# CITY OF ALBUQUE

**Re: Agenda-Global Warehouse Remodel – 1715 5th St. NW  
Erosion and Sediment Control Plan  
Engineer's Stamp Date 3/7/2022 (H14E100A)**

ESC-1

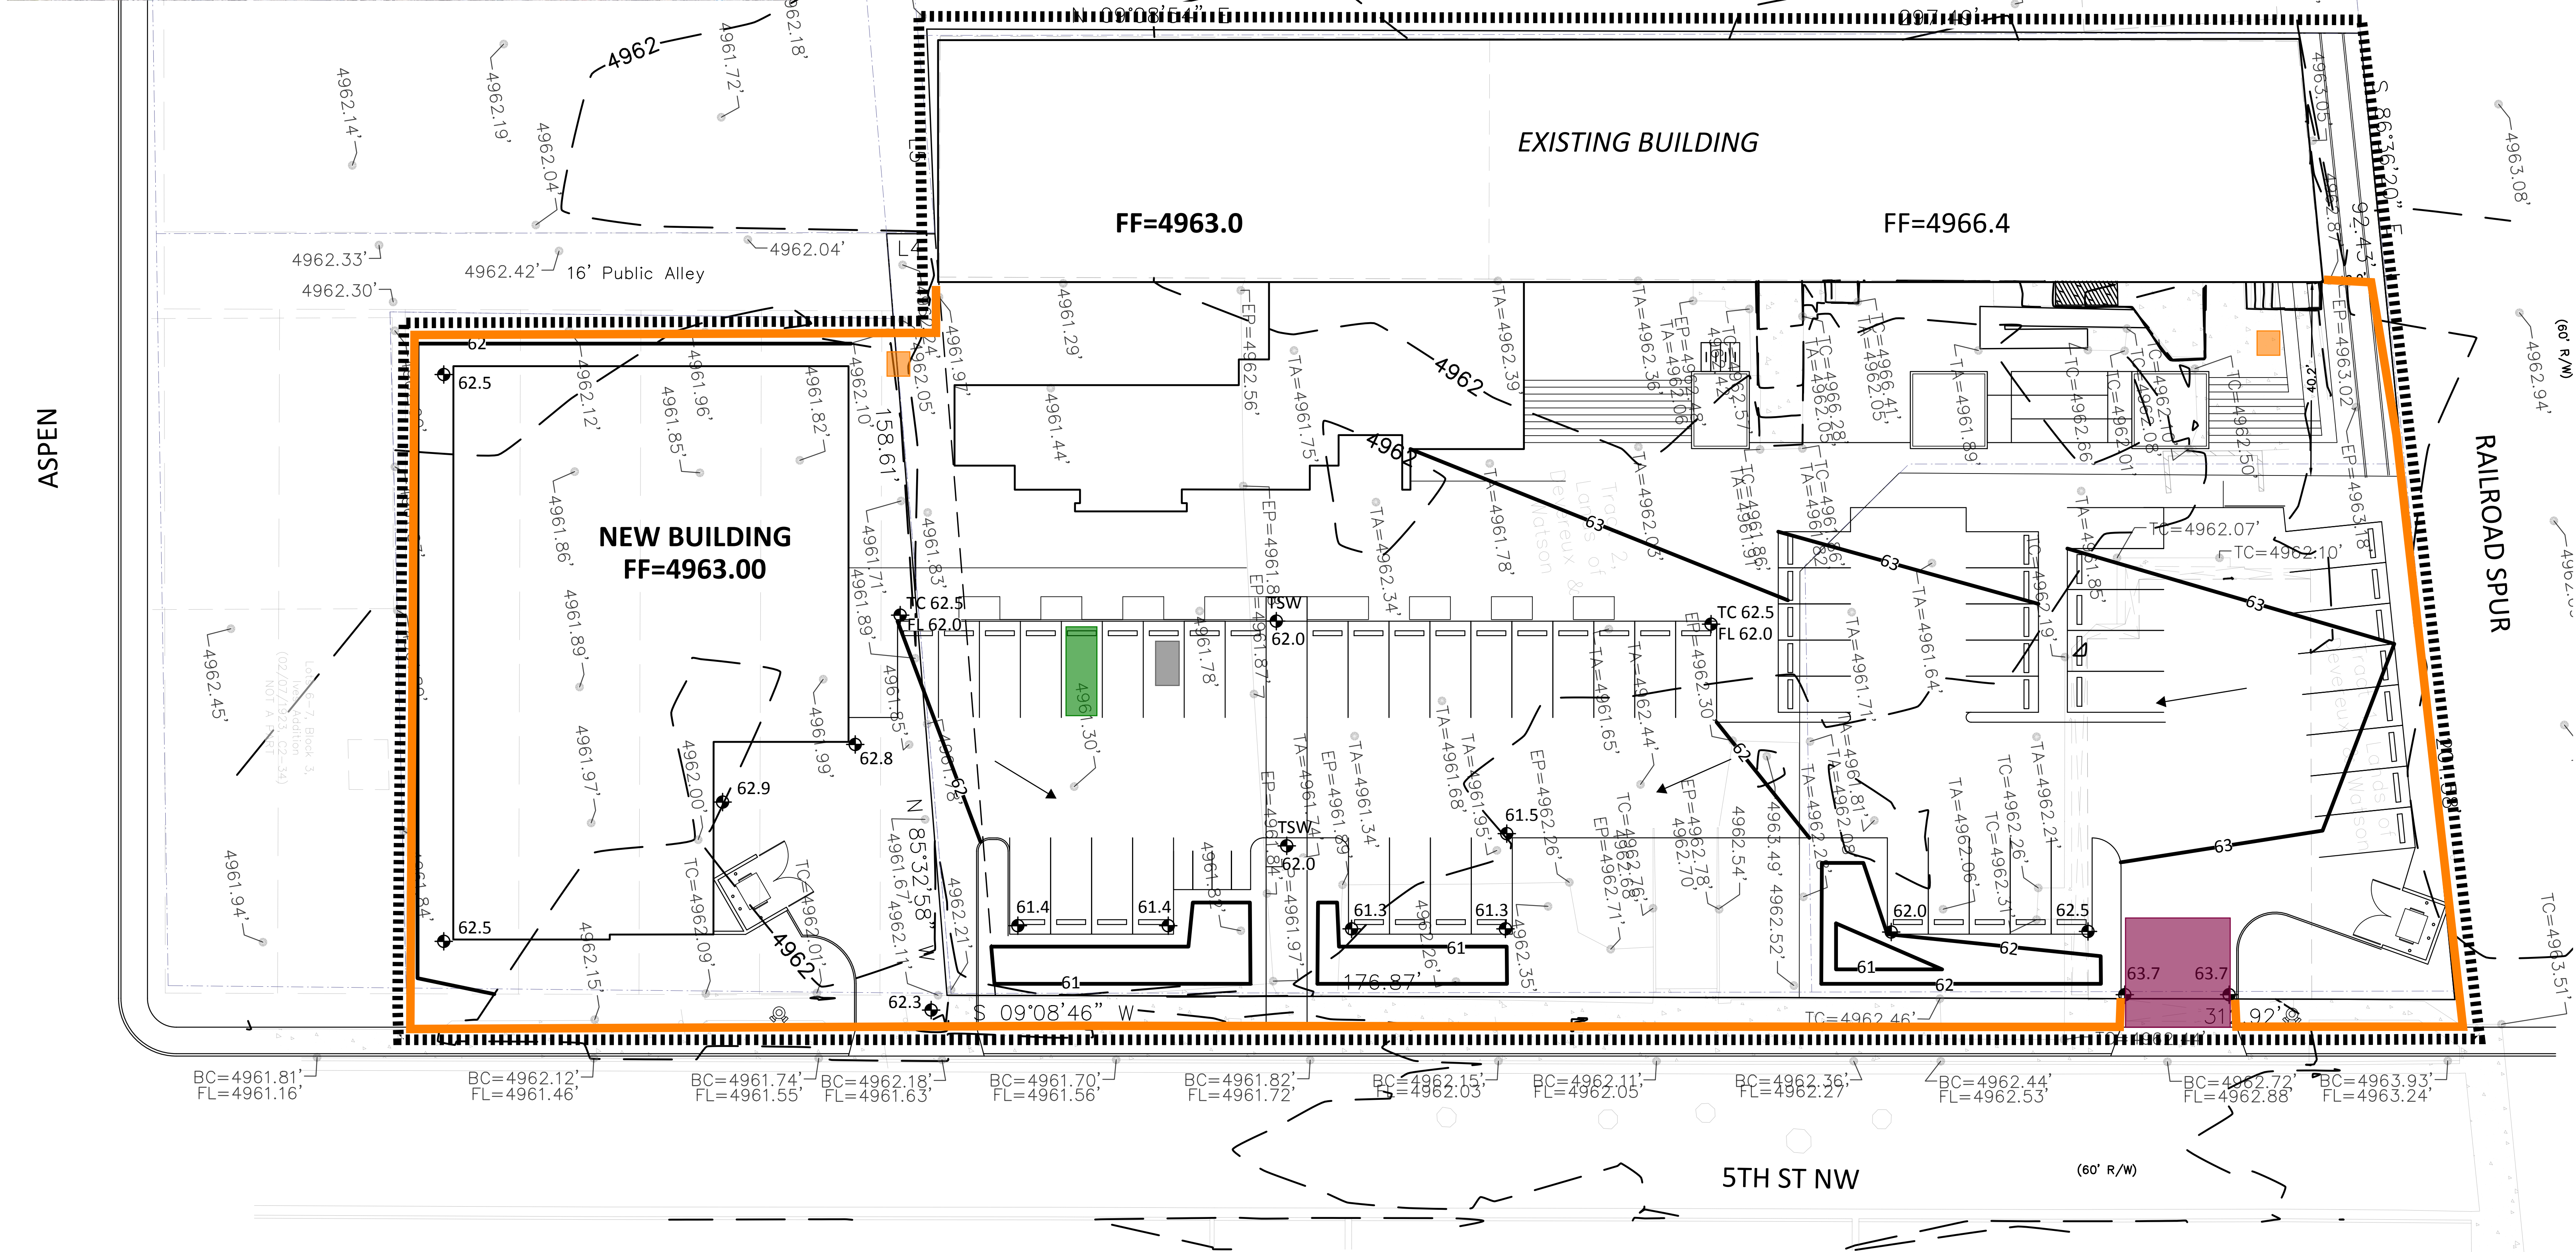
2. The limits of disturbance must include all frontage improvements (CGP7.2.4.b.i);
3. I can't tell the difference between building, sidewalk, asphalt, and dirt on the ESC Plan. These structures must be clearly identified in the SWPPP per CGP 7.2.4.b.vi. The same information is required in the ESC Application. You may attach a copy of the Site Plan (or TCL) to both the SWPPP and the ESC Application to address this requirement.

5. Describe undisturbed and pre-construction ground cover (CGP7.2.4.e);
6. Identify locations of concentrated flow paths that exit the disturbed areas. Show on-site drainage patterns of stormwater before and after major grading activities (CGP7.2.4.f).

7. List operators on the plan, including name, phone #, and e-mail address (CGP 7.2.1).
